April 8, 2026

RE: Easton Travel Center SEPA Checklist (SE-26-00001) – Request for Information

Parcel #'s: 778834

SCALE GRAPHIC	EASTON TRAVEL CENTER	SHEET
DRAWN BY: LVE	PARCEL SITE PLAN	1
CHECKED BY: LVE	EASTON, WA	
SURVEYED BY:	DATE: FEBRUARY 13, 2024

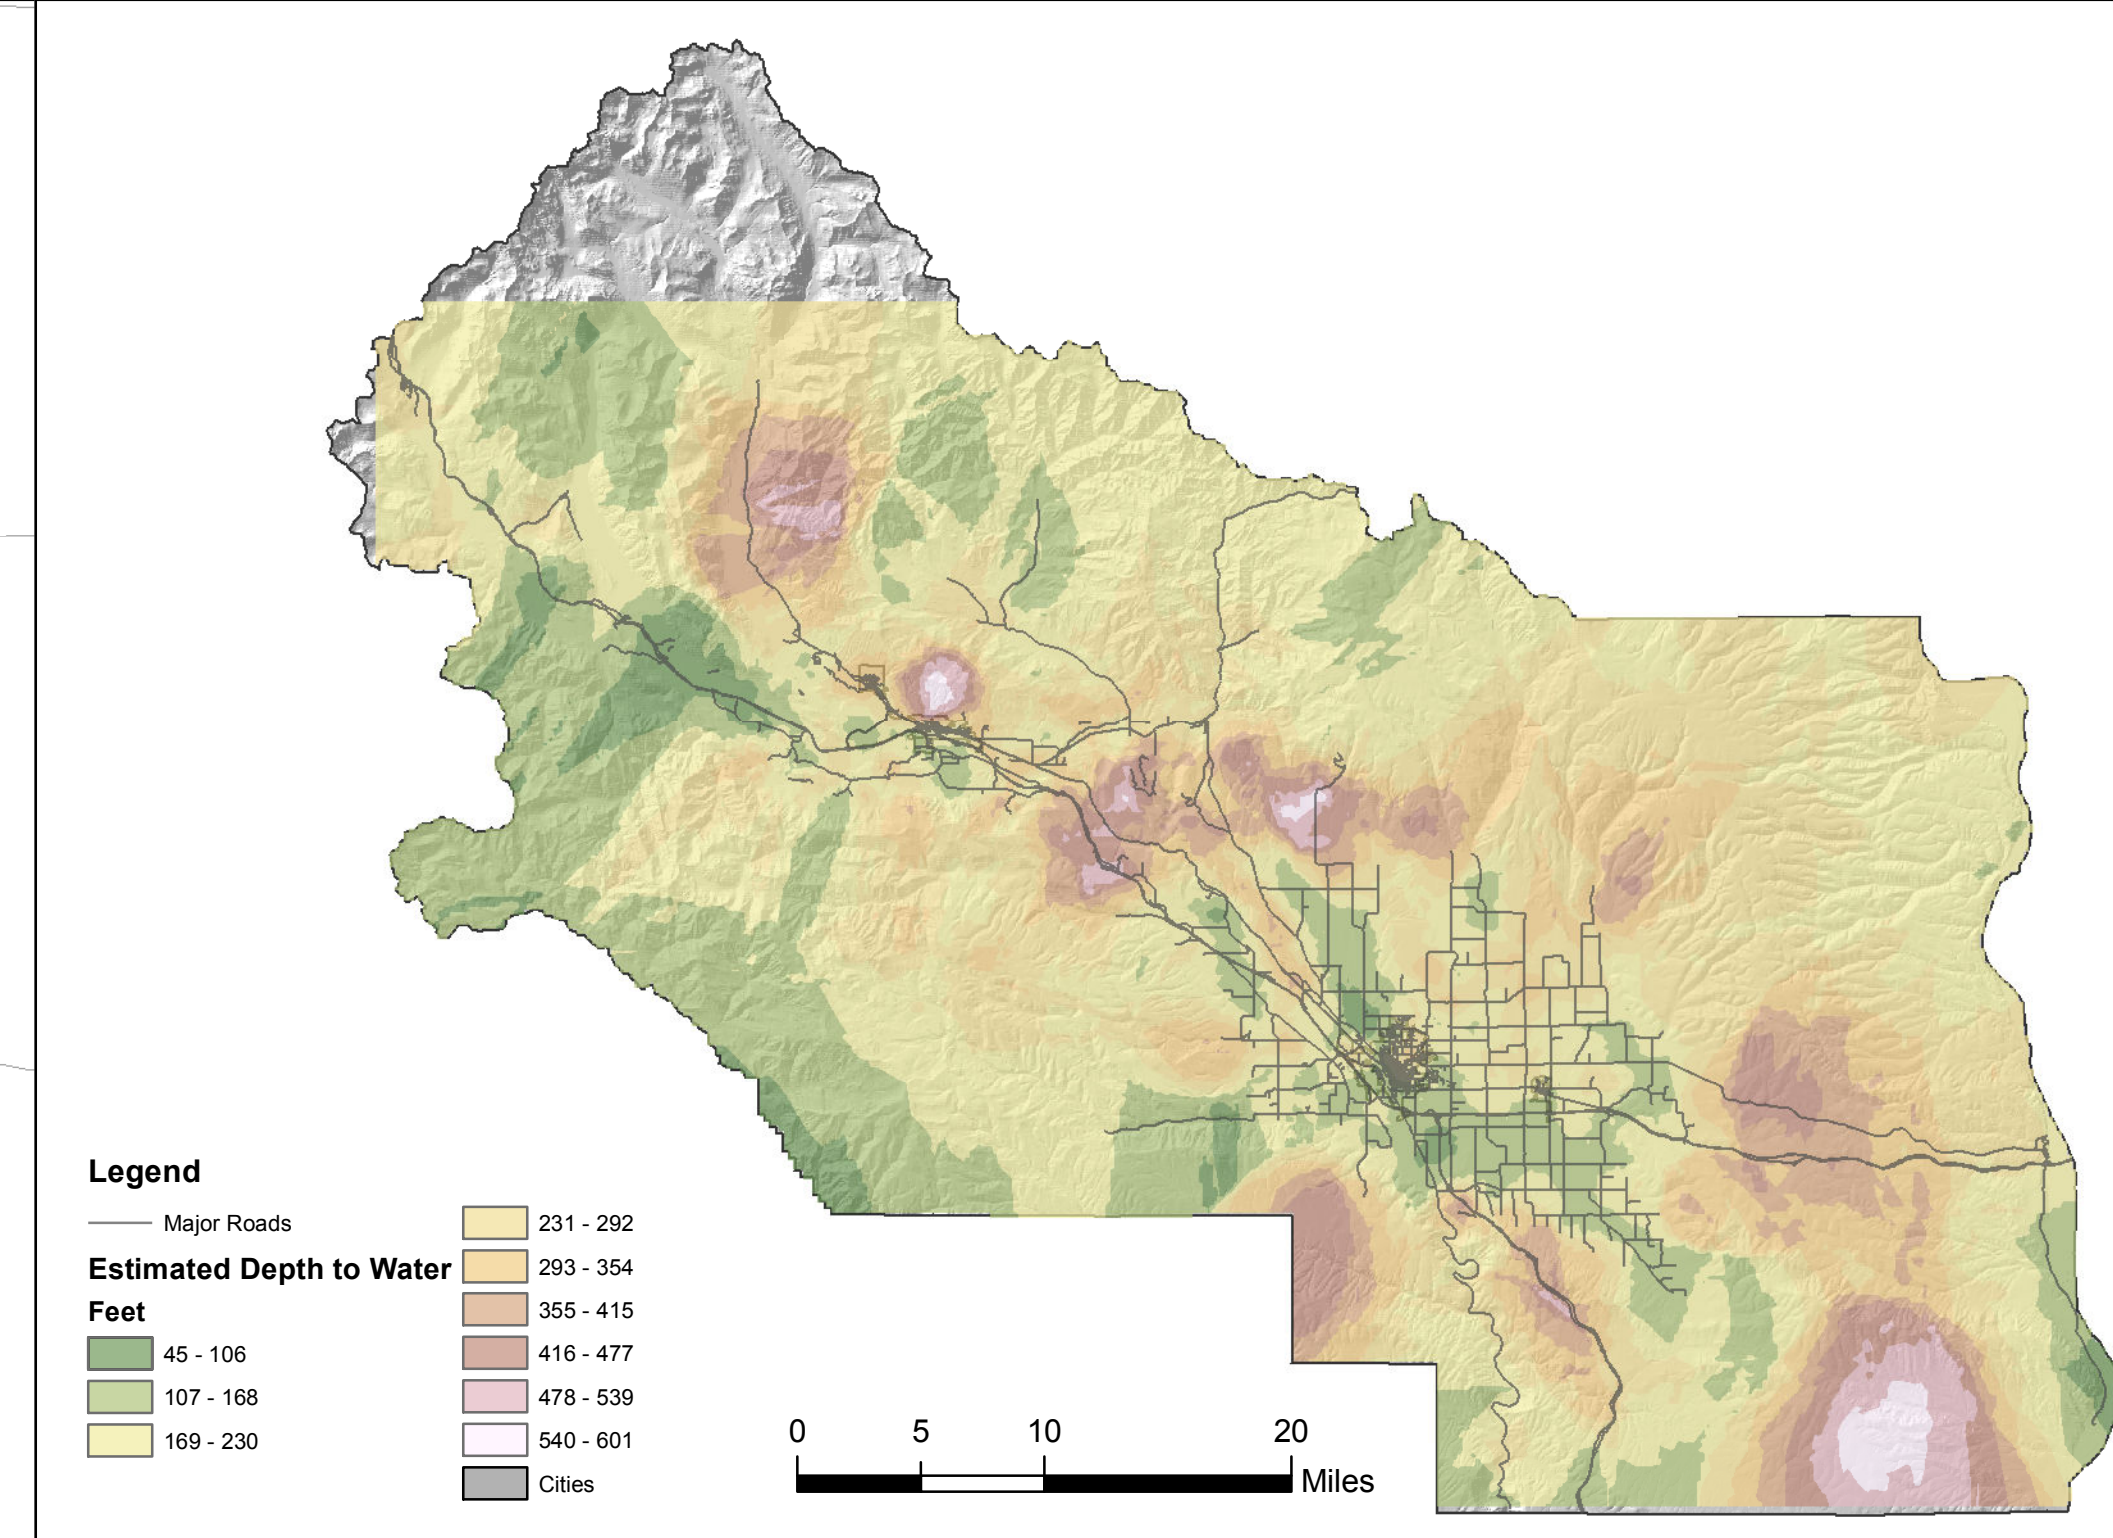
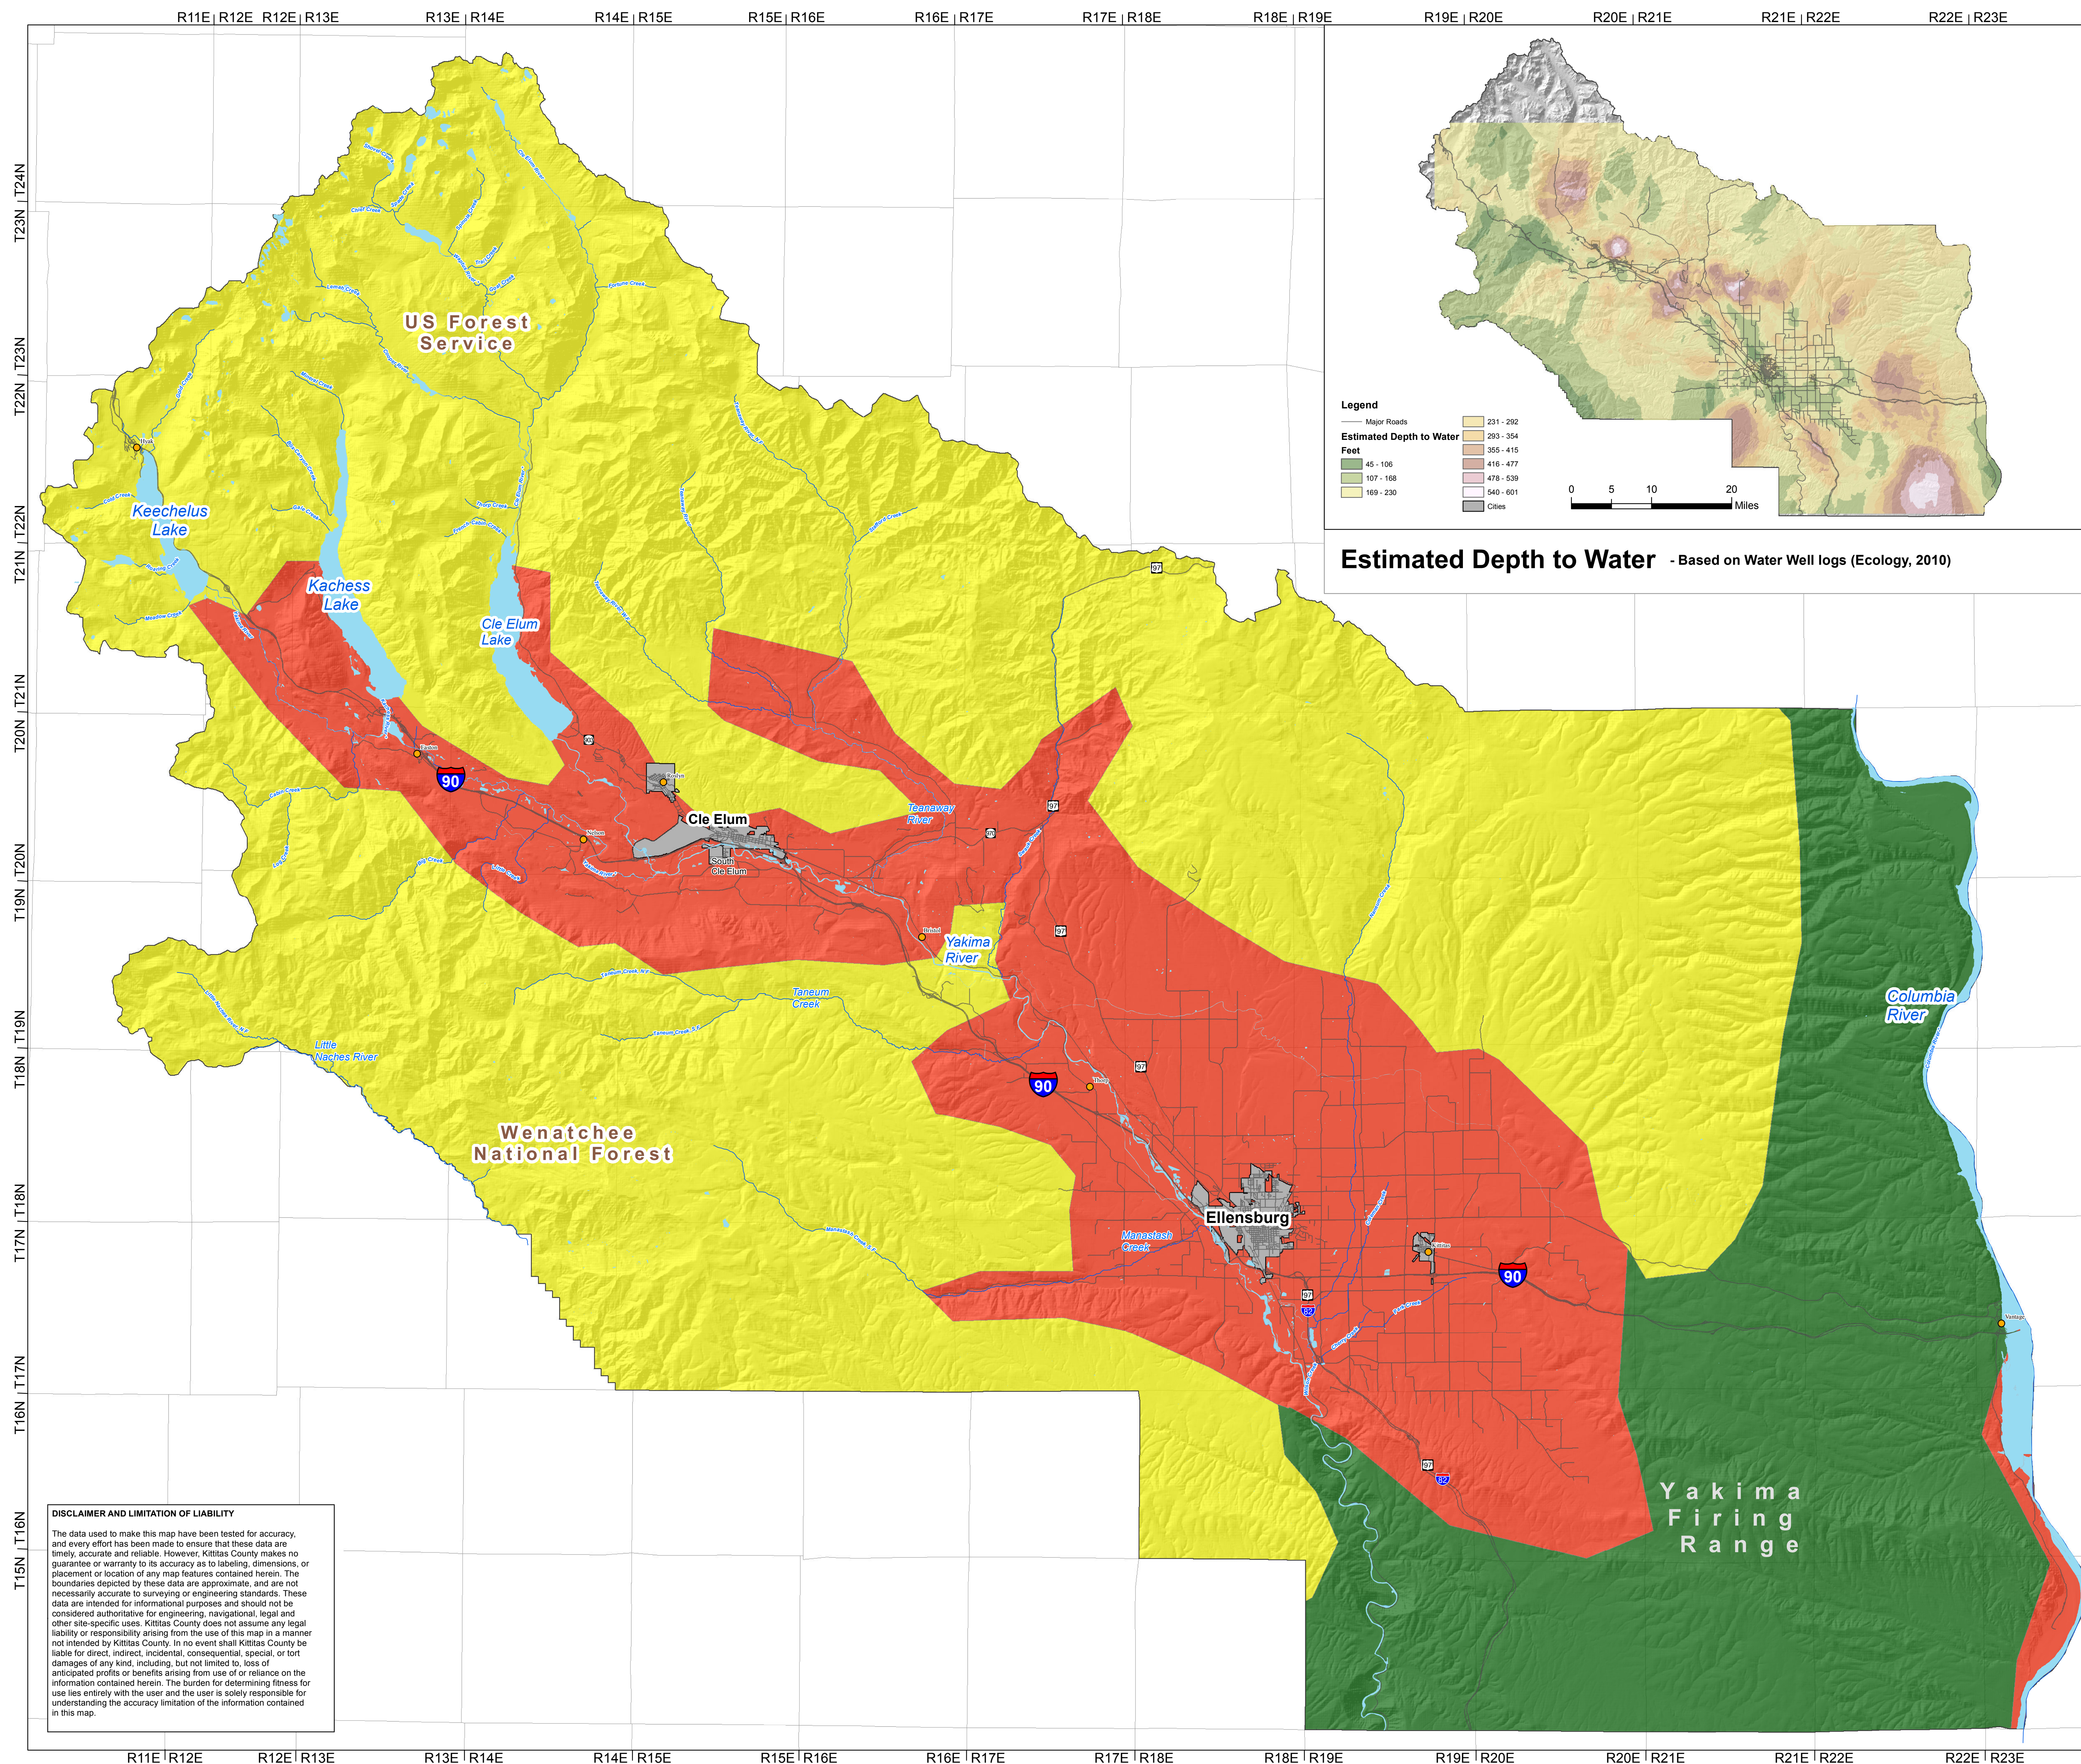
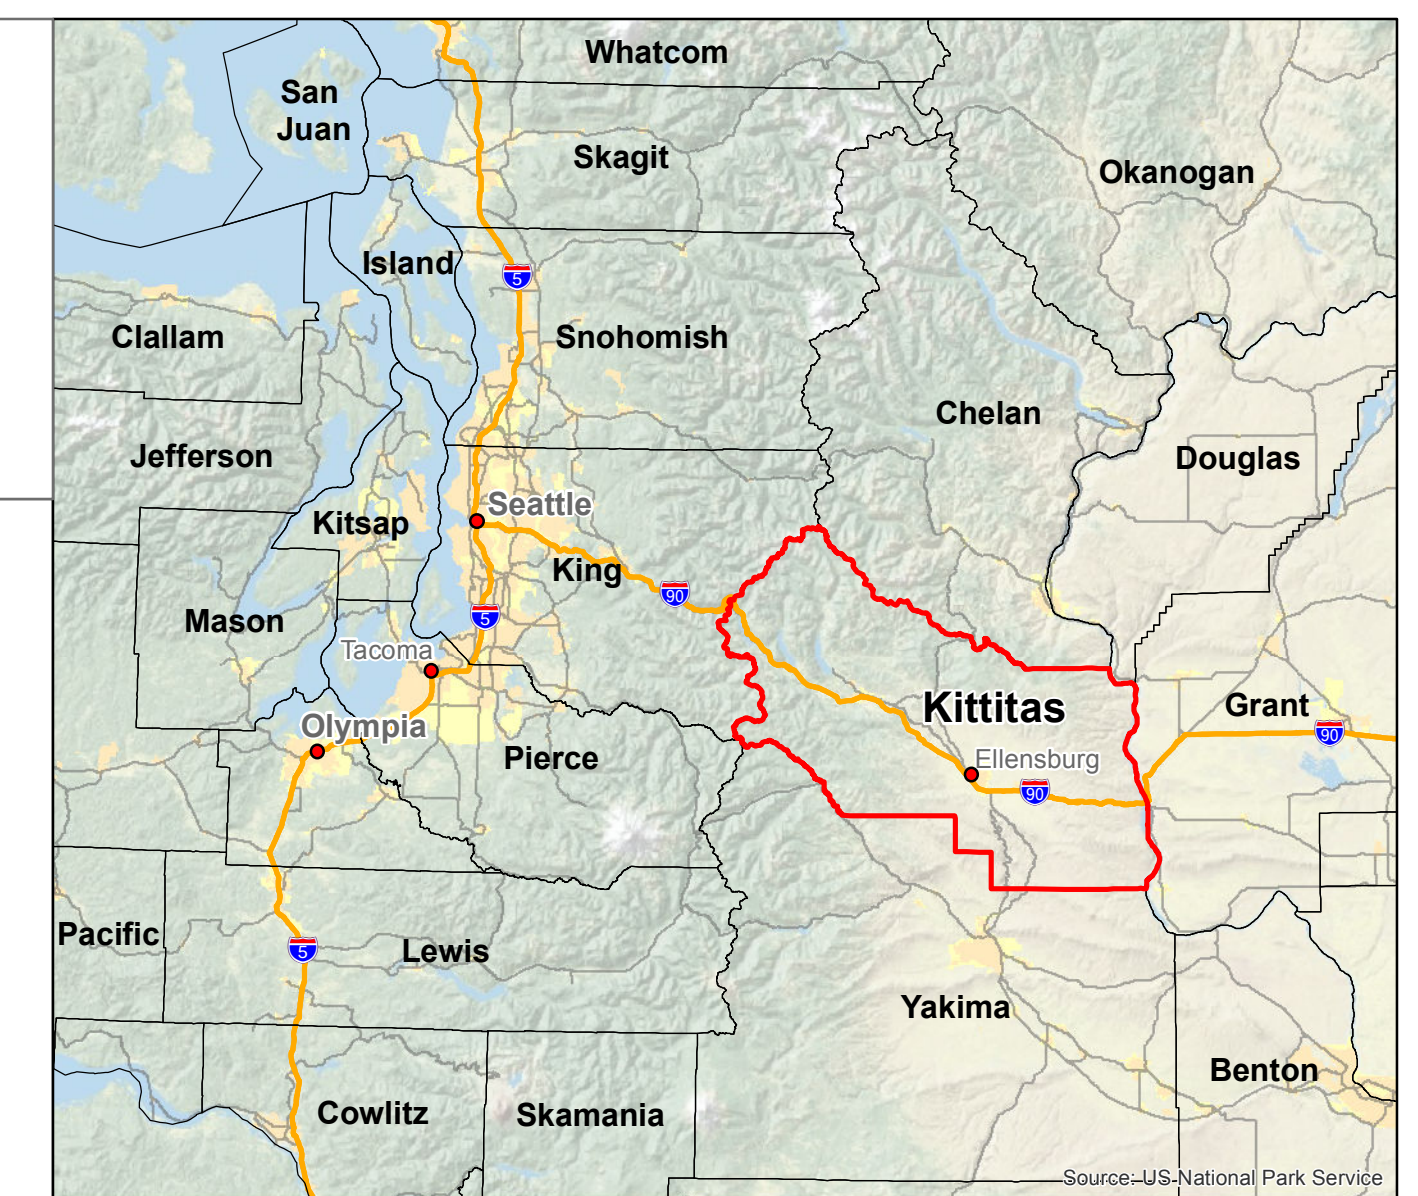
1. The site plan submitted via email on April 3, 2026 contained information that requires clarification. This most recent site plan shows a 10,000 SF store. The site plan received on 4-1-26 shows a 10,000 SF building. The labeling for the same building differs between site plans. Previous email communication from you, dated March 3, 2026 states that any retail would be related to automotive products like oil and coolant. The label “store” implies retail versus restaurant & deli. An email dated March 3, 2026, is accompanying this memo as evidence of the previous communication. The county needs clarification on the intended use of the 10,000 SF building. When responding to this request for information, please be specific with the intended uses of the proposed development and the 10,000SF building.

2. The same site plan, referenced in #1 above, now shows a “Dedicated metal shed for County snow trucks/plows.” According to KC Public Works, there is no agreement to utilize this property or proposed development as storage or parking for county trucks or equipment. Please remove this label from the site plan and resubmit the site plan.

3. Please label the commercial vehicle and/or truck parking area on the site plan. Parking for commercial vehicles is listed in the SEPA checklist but not labeled on the site plan so reviewers understand where it’s being proposed.
